**KIRKLEES METROPOLITAN COUNCIL
INVESTMENT & REGENERATION SERVICE**

DELEGATED DECISION TO DETERMINE PLANNING APPLICATIONS

Reference No:	2025/62/91373/W
Site Address:	Hill Top Farm, Weather Hill Lane, Cartworth Moor, Holmfirth, HD9 2SF
Description:	Erection of single storey side extension, solar panels to roof and associated alterations
Recommending Officer:	Joanna Rednall

DECISION – CONDITIONAL FULL PERMISSION

Client
Mr & Mrs A Lea
Drawing Title/Issue
General Arrangement as Proposed

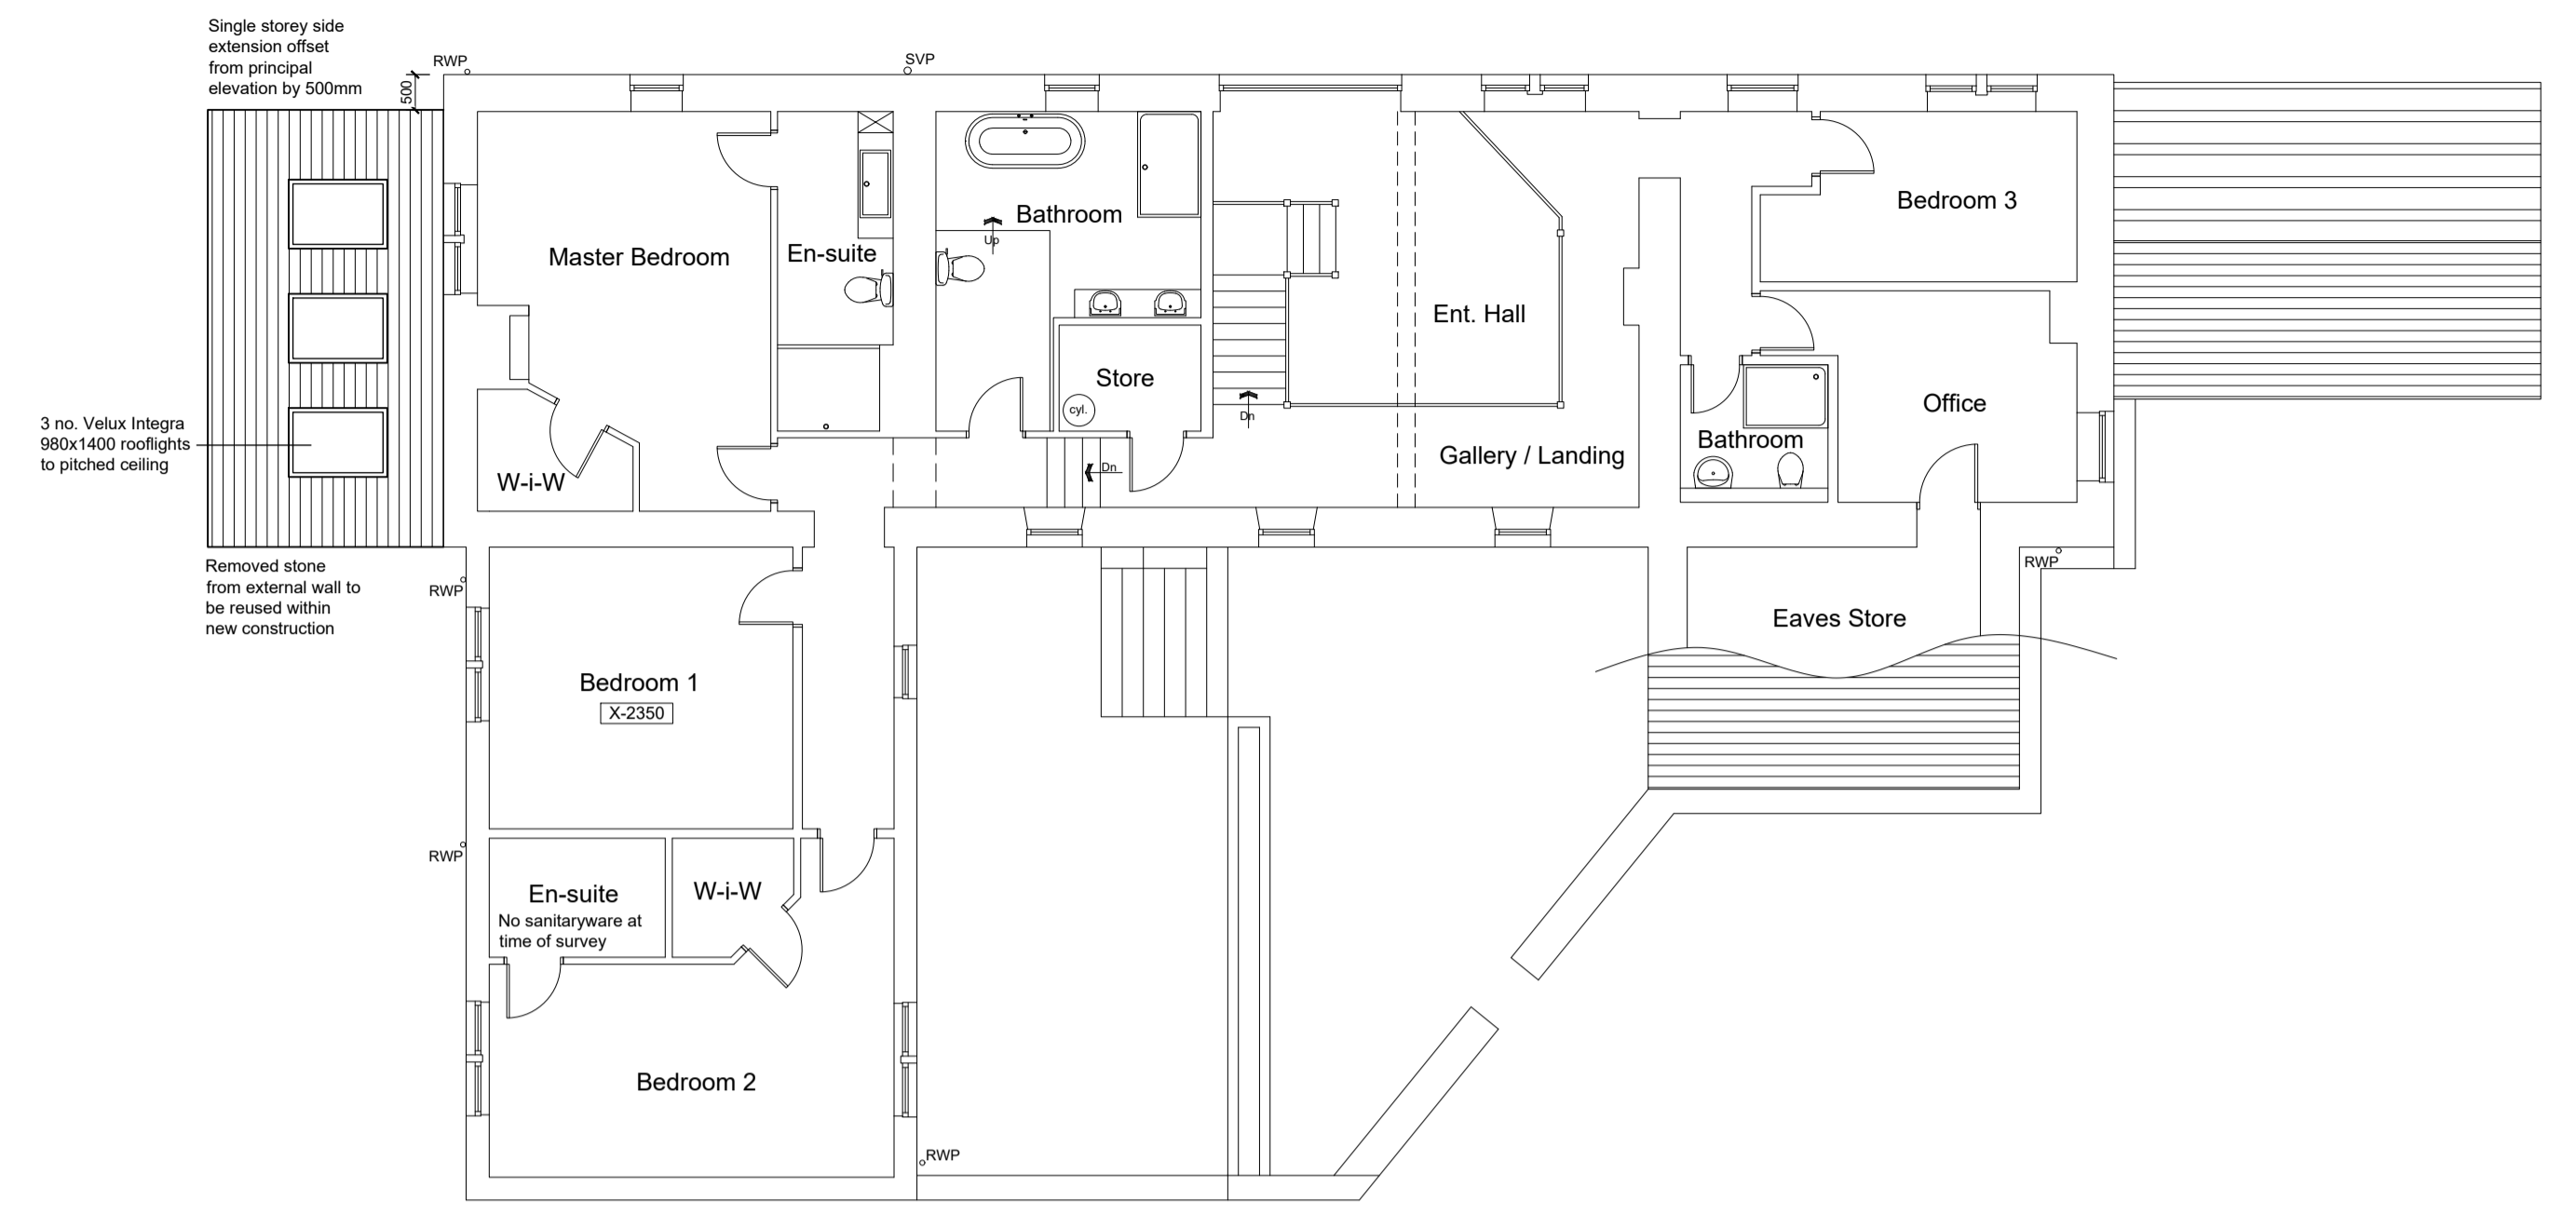
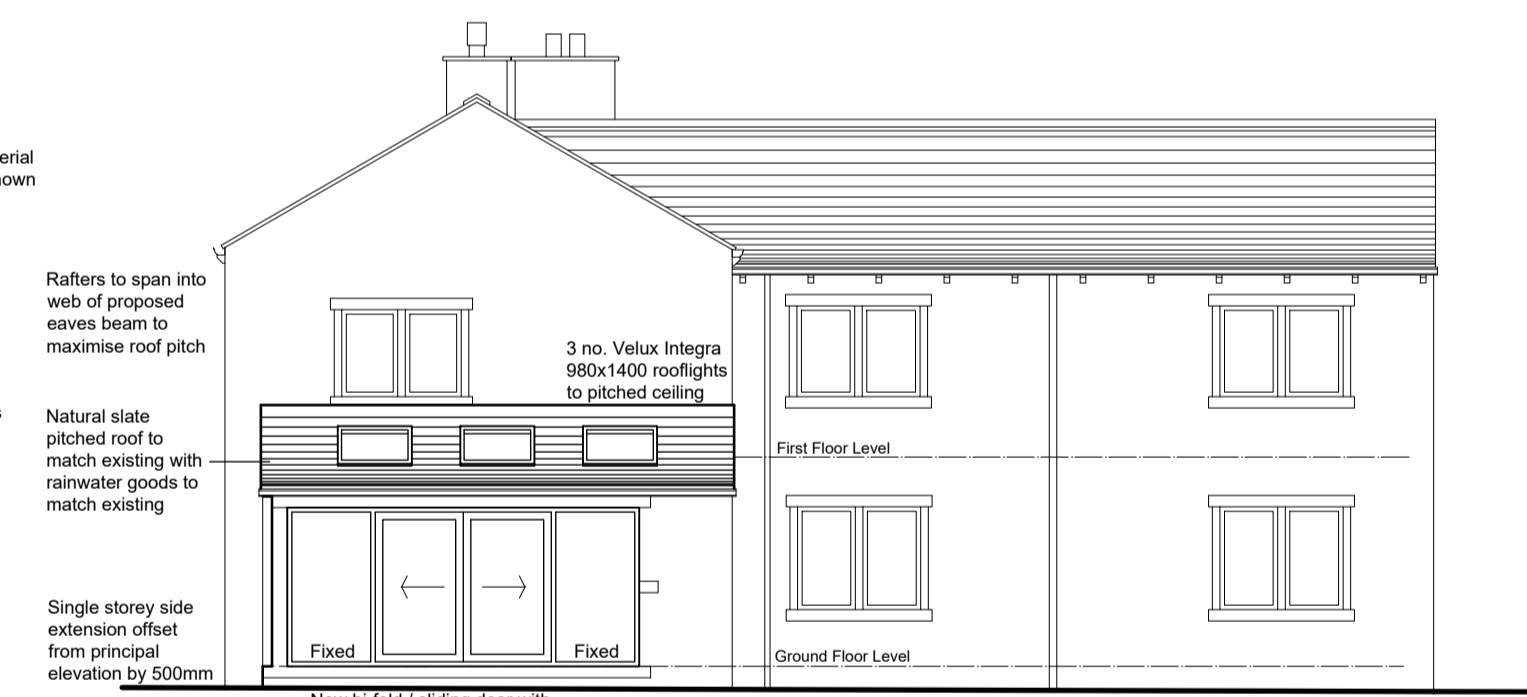
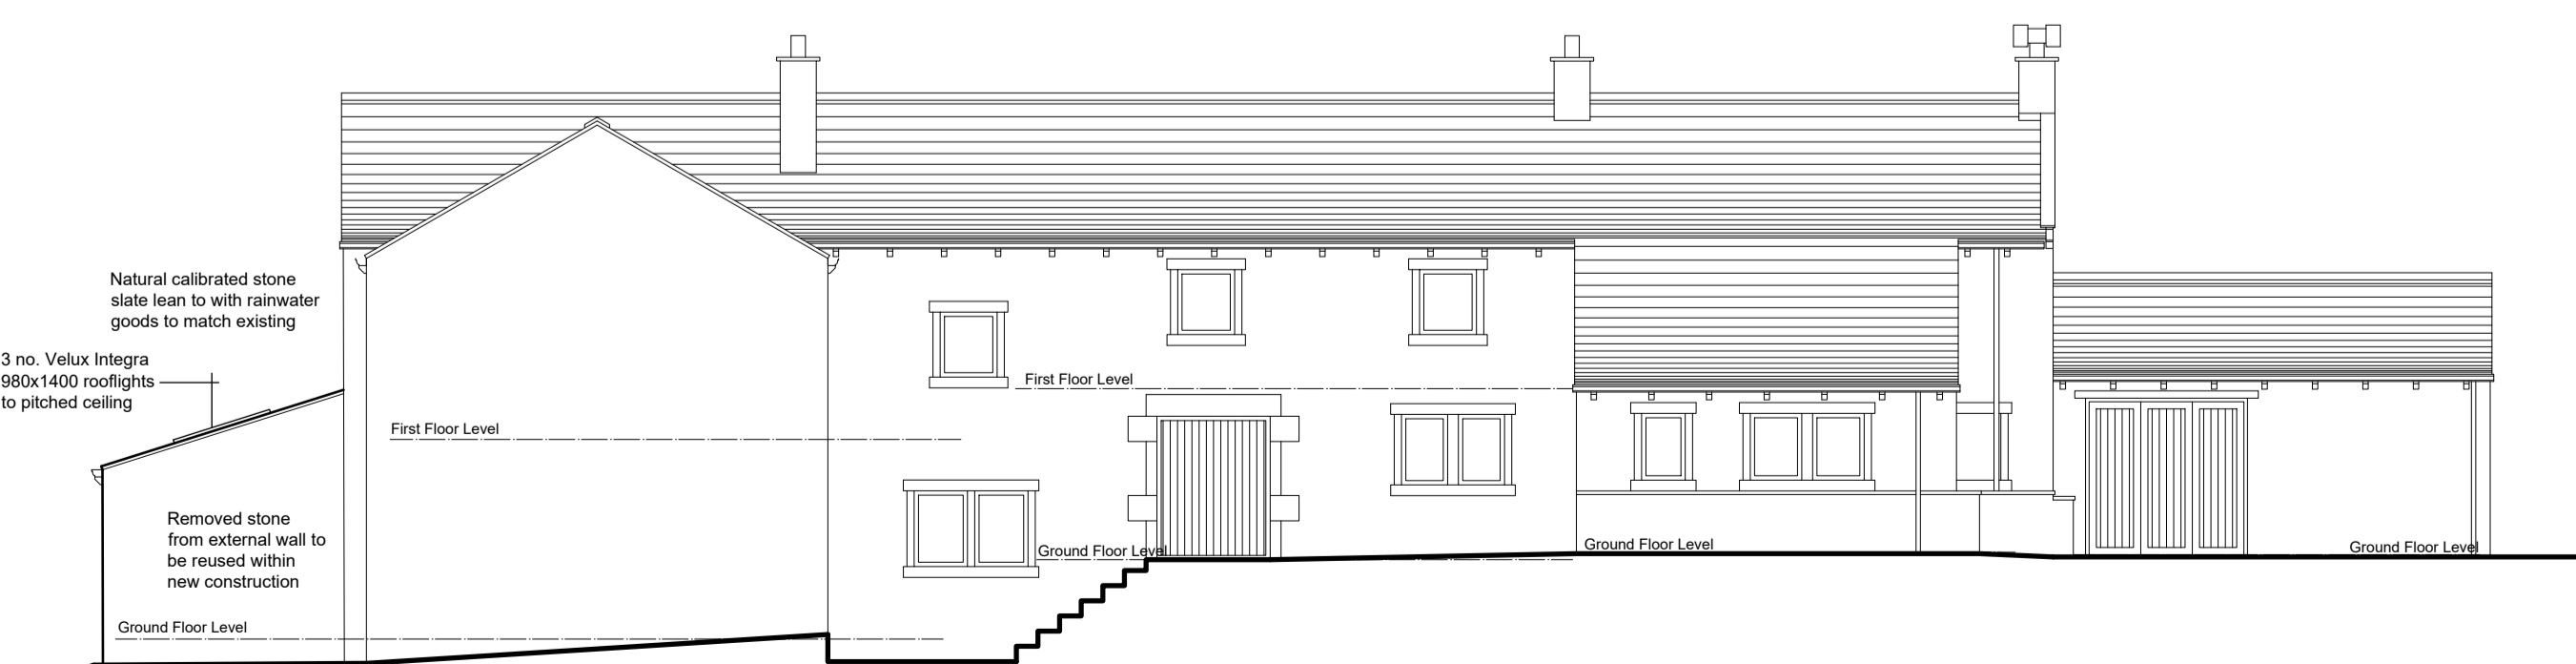
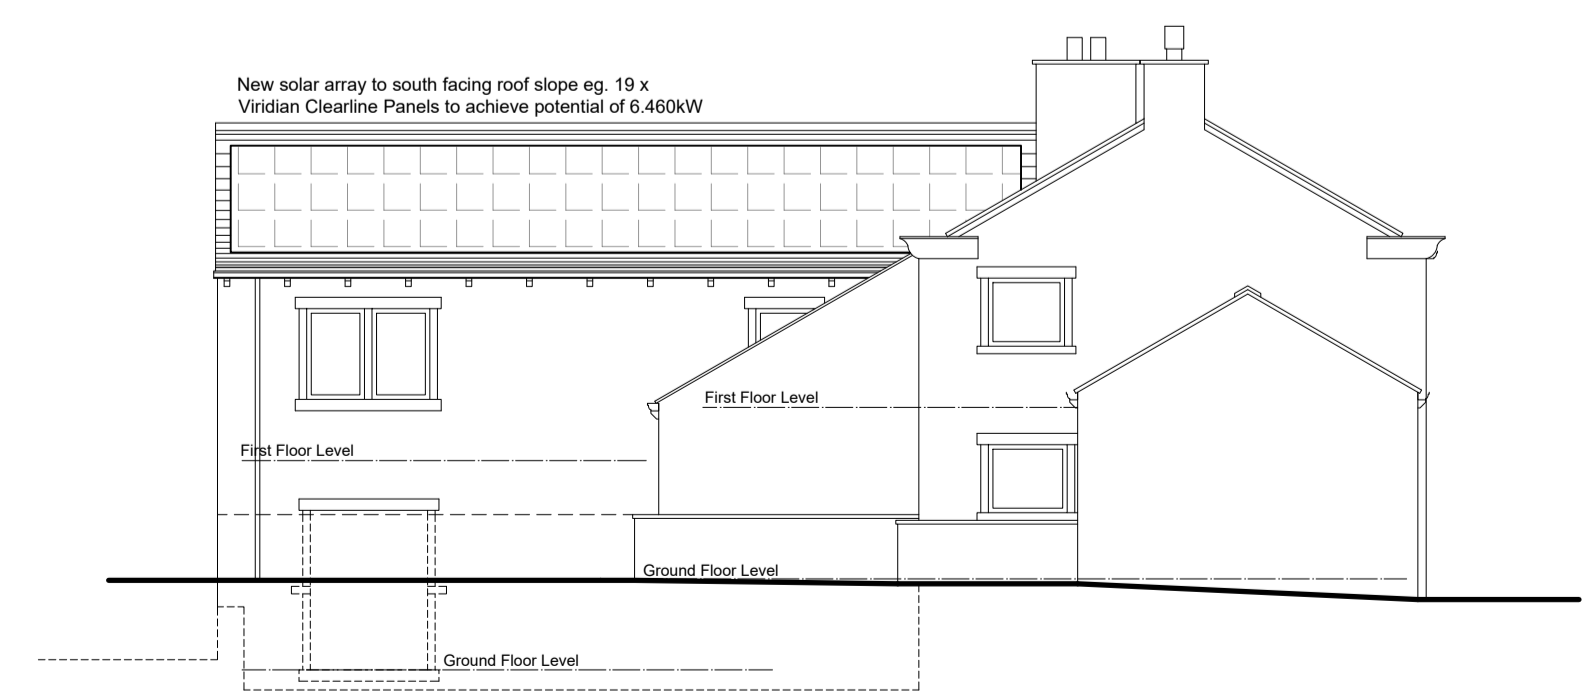
The extension extends approximately 3.3 metres from the north-facing elevation and spans about 6.2 metres in width. It has eaves standing around 2.5 metres high, with the total height reaching approximately 3.7 metres to the ridge of the lean-to roof. When compared to the host dwelling, the extension is clearly a balanced and proportionate addition that does not overpower or disrupt the overall appearance of the original building.

The design maintains the barn's characteristic linear form, with the proposed extension complementing the existing structure. The use of materials that match the host building will enhance this cohesive appearance, and to ensure

The proposal meets the SPD design guidelines, ensuring the height remains below 4 metres and positioning the extension well back from the side elevations. These factors combine to keep the extension visually subordinate and appropriately scaled in relation to the main dwelling.

The proposed development includes the installation of 19 solar panels on the south/ side facing roof slope of the dwelling. The panels would be mounted in a fixed position, recessed within the roof slope, and would not protrude beyond the ridge or edges of the roof. The solar panels are proposed to the side elevation and due to the building's rural location, would not appear overly prominent from public realm and would not adversely affect the appearance of the street scene or the visual amenity of the surrounding area. In terms of design and appearance, the installation is considered appropriate within the domestic context of the property.

3. The external walls and roofing materials of the extension hereby approved shall in all respects match those used in the construction of the existing building.
